CITY OF ALBUQUERQUE

October 7, 2005

Re: Approval of Temporary Certificate of Occupancy (C.O.) for
WAREHOUSE ON ASPEN, [J-14 / D145]
300 Aspen Avenue NW
Engineer's Stamp Dated 09/23/05

REFERENCE: Traffic Circulation Layout Plan and Grading and Drainage Plan for Tract A-2, at 300 Aspen Avenue NW, (J14-D145)

SHEET TITLE: DRAINAGE AND GRADING PLAN

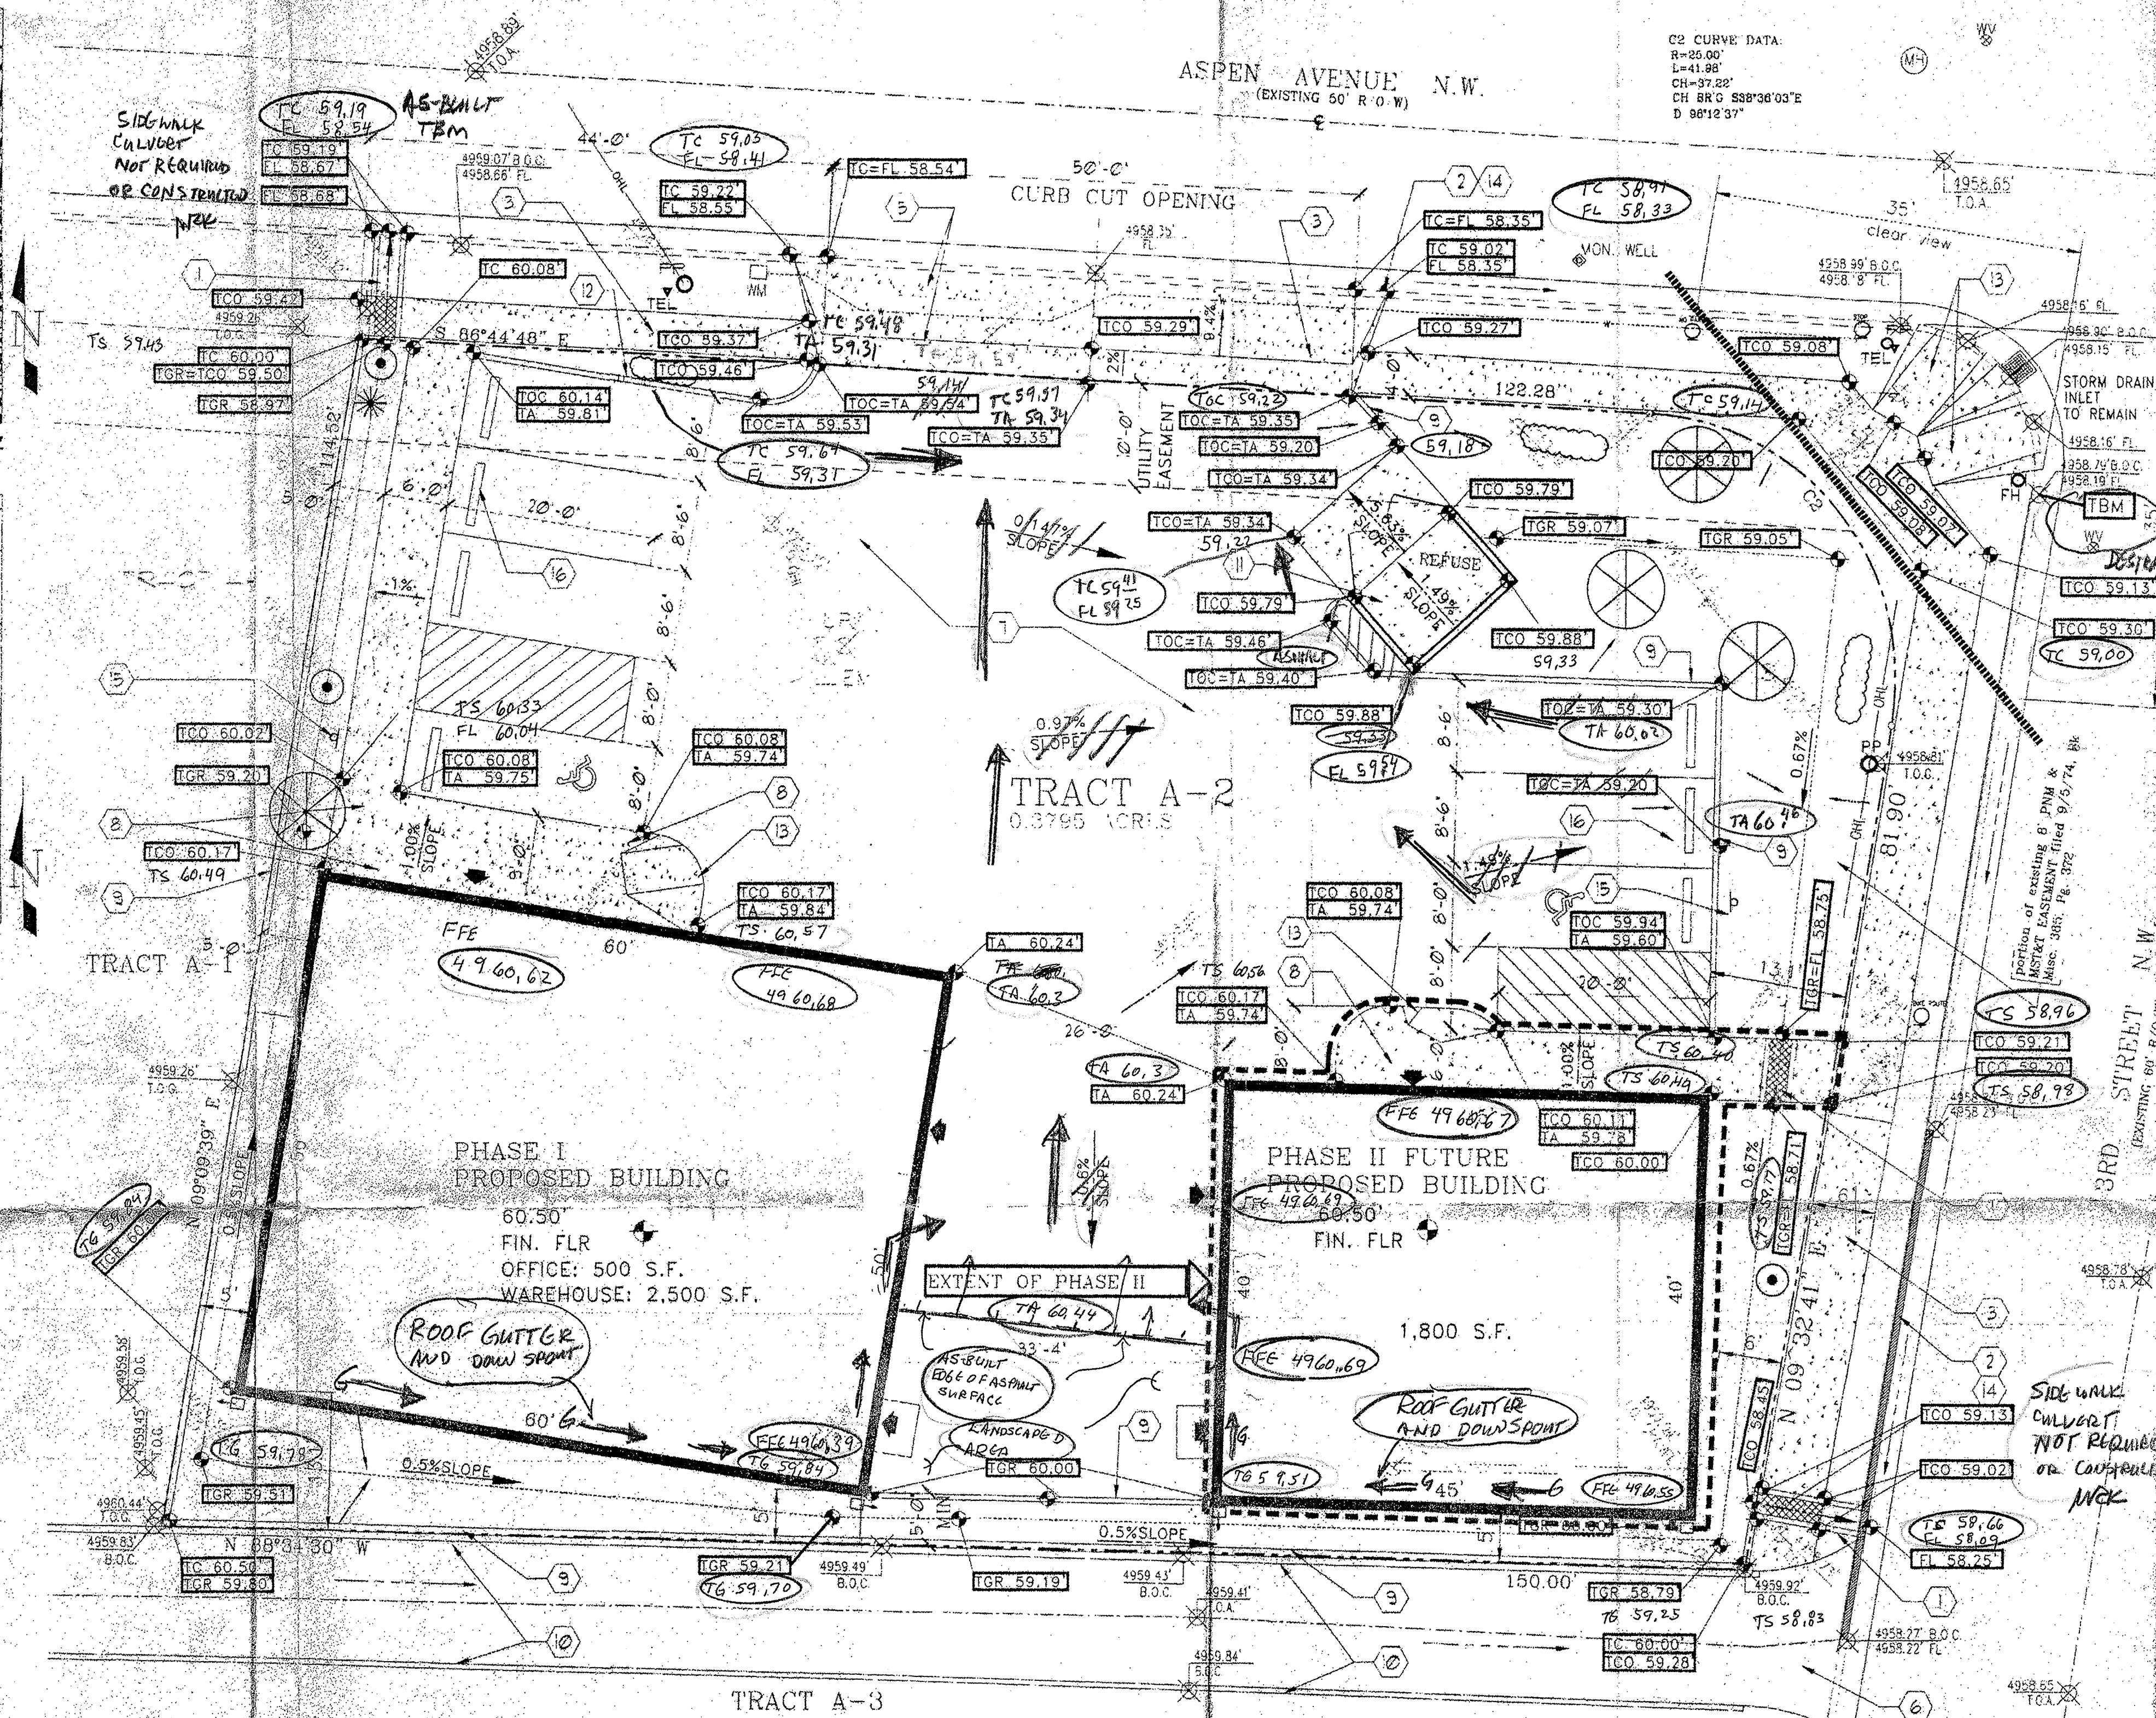
1. The sidewalk culvert on the southeast corner of the property (3rd Street) and the sidewalk culvert on the northwest corner (Aspen Avenue) are not constructed.

2. The hole at the west end of the sidewalk on Aspen Avenue has been filled, but has settled due to the rain. This hole and trench were the result of Quest installing underground communications lines.

3. There are some sections of sidewalk near the southeast corner of the property that are cracked and settling, resulting in jutting edge of the adjacent drivepad.

4. The asphalt pavement along the east side drains to the landscaped area in the northeast corner of the property (this is generally according to the approved G & D plan). The landscaped area has settled along the property line on Aspen, which is causing an undercutting of the sidewalk

5. The asphalt surface of the parking area on the northern part of the property (along Aspen Avenue) is settling or was placed at too low of an elevation to drain over the drivepad onto Aspen Avenue.

6. The concrete curb along the south and west side of the property has not been constructed.

1. The sidewalk culverts will be deleted as a requirement when the remedial actions stated in the following paragraphs are completed.
2. The hole and trench along the northwest corner will be filled and compacted.

3. The broken sidewalk sections will be removed, the subgrade compacted according to the City of Albuquerque Standard Specifications for Public Works (95% for 12 inches below the sidewalk), and sidewalk sections constructed with a surface level with adjacent sidewalk and drivepad surfaces.

4. The landscaped area along Aspen Avenue in the northeast corner of the property will be raised to a surface elevation level about 1 inch below the sidewalk top surface, then sloping into the landscaped area to have runoff enter the landscaped area. The width of this part of the landscaped area that is higher than the rest of the landscaped area will be about 5 feet to prevent water standing against the sidewalk and undermining the sidewalk. It is noted that the approved plan was for this landscaped area to drain toward the sidewalk culvert in 3rd Street, near the southeast corner of the property. The overall shallow slope of the landscaped area and the street gutter along 3rd Street result in a surface that has a slope of less than 1 %, a slope too shallow for good runoff flow.

5. The depressed asphalt surface along the north part of the parking area will be paved with additional asphalt to insure that surface runoff from the asphalt surface will flow over the driveway and into the gutter along Aspen Avenue. There is sufficient drop from the building floor elevation to the top of drivepad to obtain an adequate slope for runoff with no deep depressions (bird baths).

6. The curb along the south and west side (and as necessary along the east side) will be constructed with treated timbers, 6" x 6" cross section, and to the height specified on the drawing, which is about the height of the finished concrete floors. The area between the building and the curb will be covered with landscape gravel to a depth of about 6 inches to absorb and hold the direct precipitation. The roof runoff to the south sides of the building will be caught in roof gutters, and downspouts to direct the roof runoff to the asphalt surface north of the buildings. At the time of the meeting on-site the roof gutters were being installed.
